Ribble Valley Borough Council
Council Offices
Church Walk,
Clitheroe
Lancashire
BB7 2RA

Phone: 0300 123 6780
Email: developeras@lancashire.gov.uk
Your ref: 3/2026/0375
Our ref: 3/2026/0375/HDC/KW
Date: 30 June 2026

Location: Playing Field Edisford Road Clitheroe BB7 3LA
Proposal: Proposed synthetic turf pitch, including fencing, acoustic barrier, floodlighting, access path, toilet block and ancillary equipment.
Grid Ref: 372910 441348

Figure 3.9 Cycling Isochrone, 20-Minute Distance
Source: TravelTime data (QGIS output)

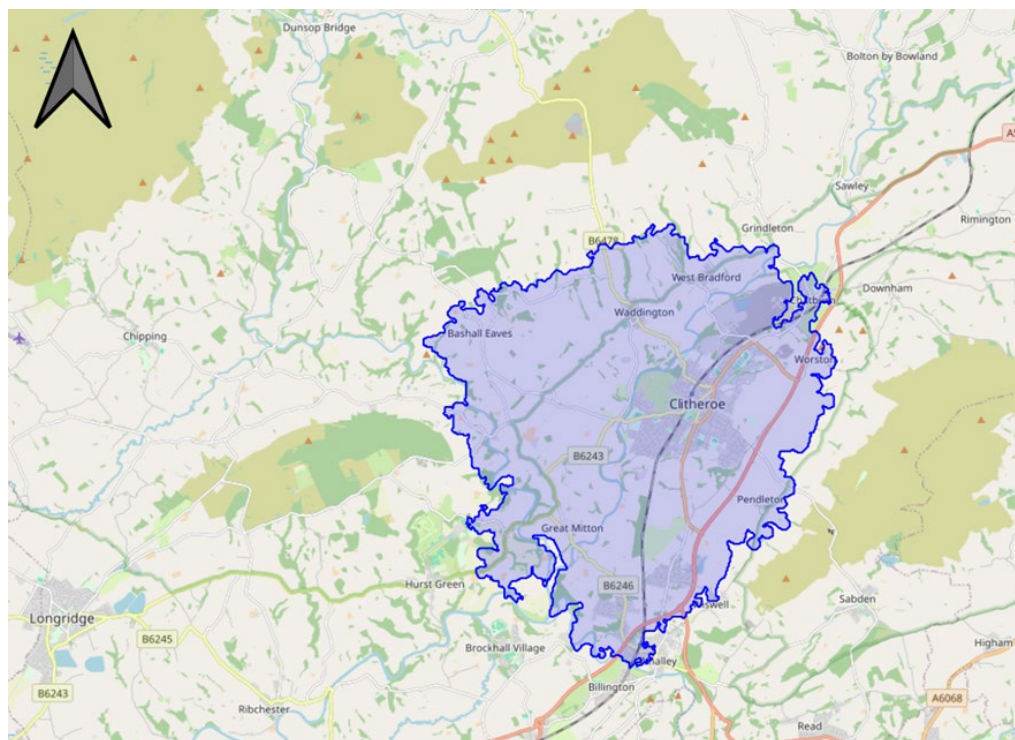
In terms of cycling, whilst there are no segregated cycle facilities immediately adjacent to the site, cycling accessibility mapping included within the Transport Assessment indicates that the entirety of Clitheroe, together with a number of surrounding settlements, falls within a 20-minute cycling catchment of the site. As such, the opportunity for trips to be undertaken by bicycle is considered to be reasonable, albeit dependent on user confidence in sharing carriageway space.

Figure 3.11 Collision Map
Source: Crashmaps.co.uk - 05/02/2026

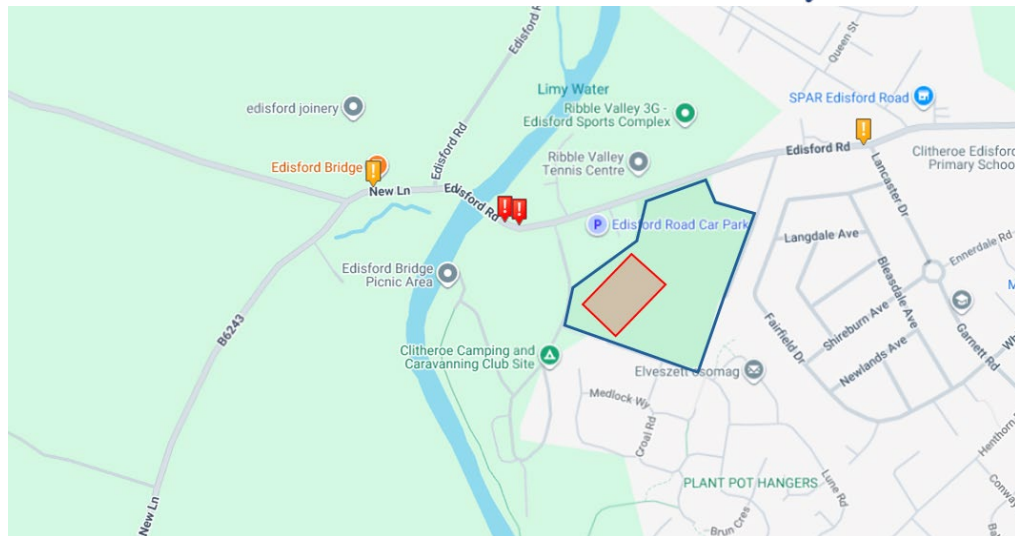
There have been five recorded Personal Injury Collisions (PICs) within 500m of the application site in the last five years. Notwithstanding this, the LHA do not have any concerns that the proposal would exacerbate the existing highway safety situation as there are no significant trends among the PICs.

Figure 6.2 Edisford Road Car Park Survey Results (Saturday 31st January)

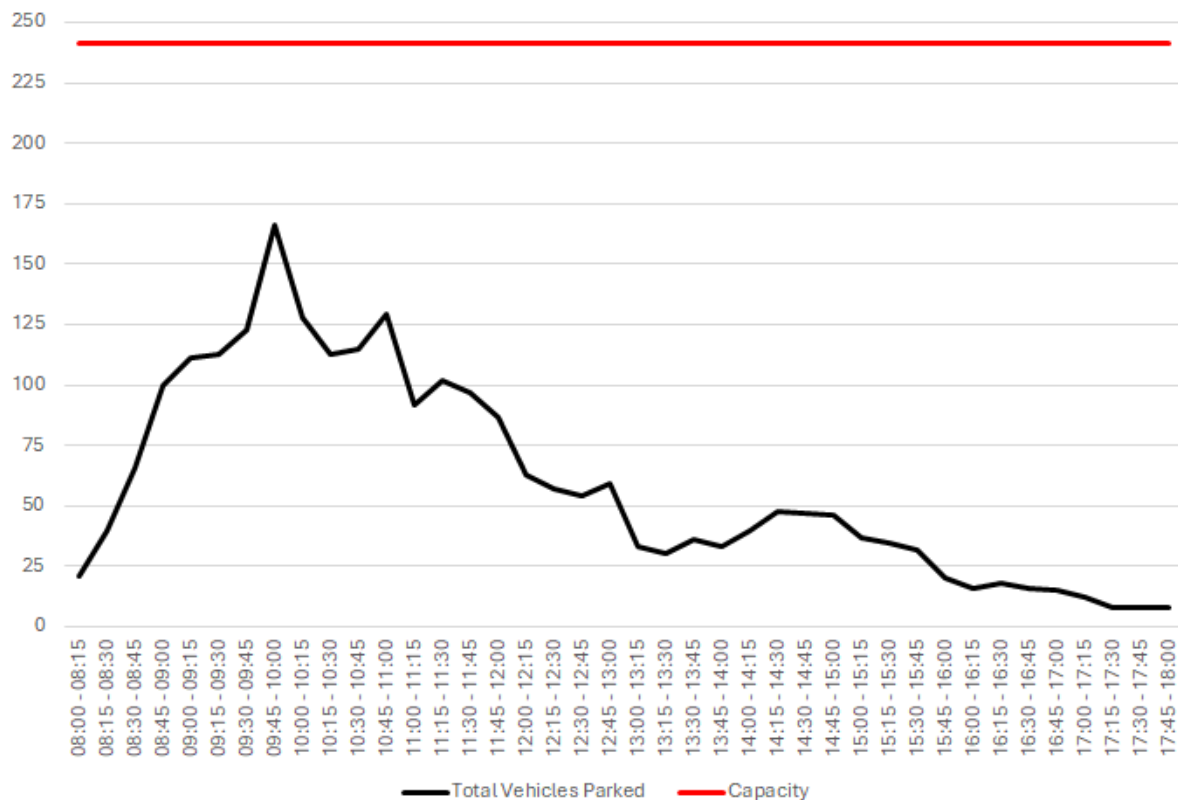
The applicant has provided a parking survey of the car park. The survey was undertaken on Saturday, 31st January 2026 (08:00 – 18:00) and Sunday, 1st February 2026 (08:00 – 18:00). The results of the survey show that within the Saturday peak, 166 vehicles were parked at 69% occupancy. The Sunday peak of 190 vehicles parked resulted in 79% occupancy. This left 75 spaces available (Saturday) and 51 spaces available (Sunday) during the peaks.

The LHA would, however, request that the parking survey be repeated during the summer months (May – July) to capture the parking demand when other uses across the sports complex and surrounding green space have a higher demand than during the winter months, such as January.

The submitted parking survey demonstrates that spare capacity exists within the car park during the surveyed peak periods. However, as the surveys were undertaken during the winter months, the Local Highway Authority requests that additional parking surveys are undertaken during the summer period (May–July), when demand associated with the wider sports complex and surrounding recreational facilities is likely to be greater. The results of these surveys will allow a more comprehensive assessment of the adequacy of parking provision associated with the proposed development.
